From: Sarah Burrow <Sarah.Burrow@arun.gov.uk>
Sent: 01 July 2021 17:29
To: Planning.Responses <Planning.Responses@arun.gov.uk>
Cc: Maria Tomalova <Maria.Tomalova@arun.gov.uk>
Subject: RE: Planning Consultation on: FP/124/21/PL

Engineers Comments Regarding Surface Water Drainage

Application No: FP/124/21/PL

Site Address: Rear of 7 Middleton Road Felpham PO22 6BL
Grid Reference: 496183 100310
Description of Works: Detached double garage. This site is in CIL Zone 4 (Zero Rated) as other development.

PL03 - Site & Location Plans

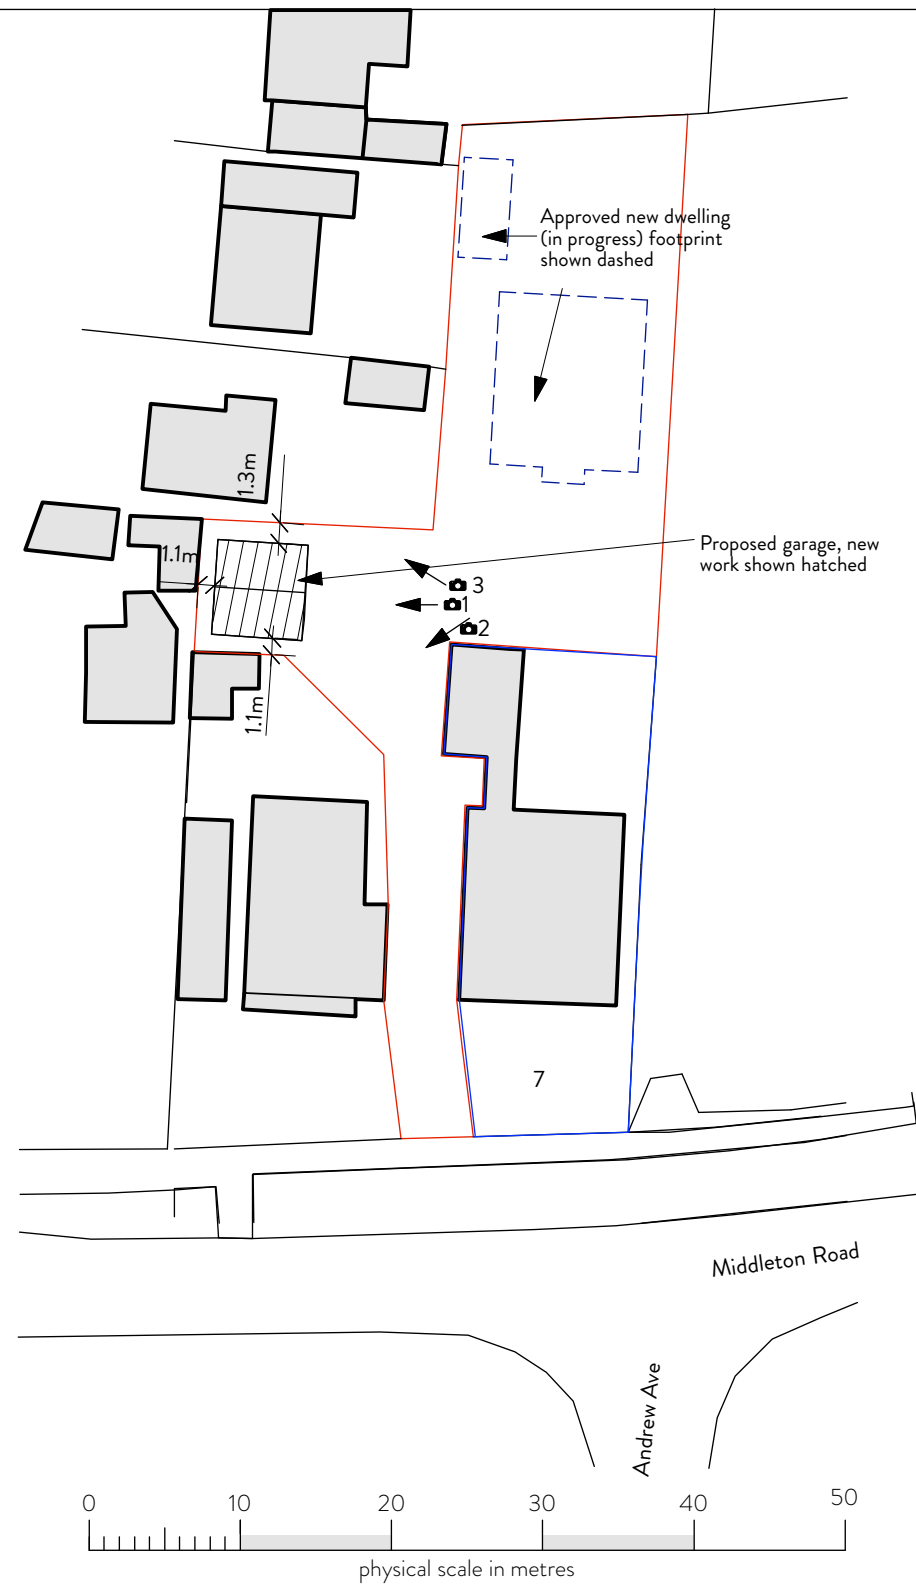
The application is within the Lidsey Treatment Catchment, therefore surface water drainage design should be carefully considered. The applicant has already got a surface water drainage design for other proposed development on the site, however, this does not account for the inclusion of the garage. I suggest that the following condition is applied and the applicant adjusts the approved surface water drainage design to account for the increased impermeable area from the proposed garage.

"Development shall not commence, other than works of site survey and investigation, until full details of the proposed surface water drainage scheme have been submitted to and approved in writing by the Local Planning Authority. The design should follow the hierarchy of preference for different types of surface water drainage disposal systems as set out in Approved Document H of the Building Regulations, and the recommendations of the SuDS Manual produced by CIRIA. No building / No part of the extended building shall be occupied until the complete

"The infiltration structure must cater for the 1 in 10 year storm event plus 40% on stored volumes (allowance for climate change) between the invert of the entry pipe to the soakaway, and the base of the structure. It must also have provision to ensure that there is capacity in the system to contain below ground level the 1 in 100 year storm event plus 40% on stored volumes. Adequate freeboard must be provided between the base of the soakaway structure and the highest recorded annual groundwater level identified in that location. Any SuDS or soakaway design must include adequate groundwater monitoring data to determine the highest winter groundwater table in support of the design. Supplementary guidance notes regarding surface water drainage are located here Council on Arun District Councils website. A surface water drainage checklist is available on Arun District Councils website, this should be submitted with a Discharge of Conditions Application."
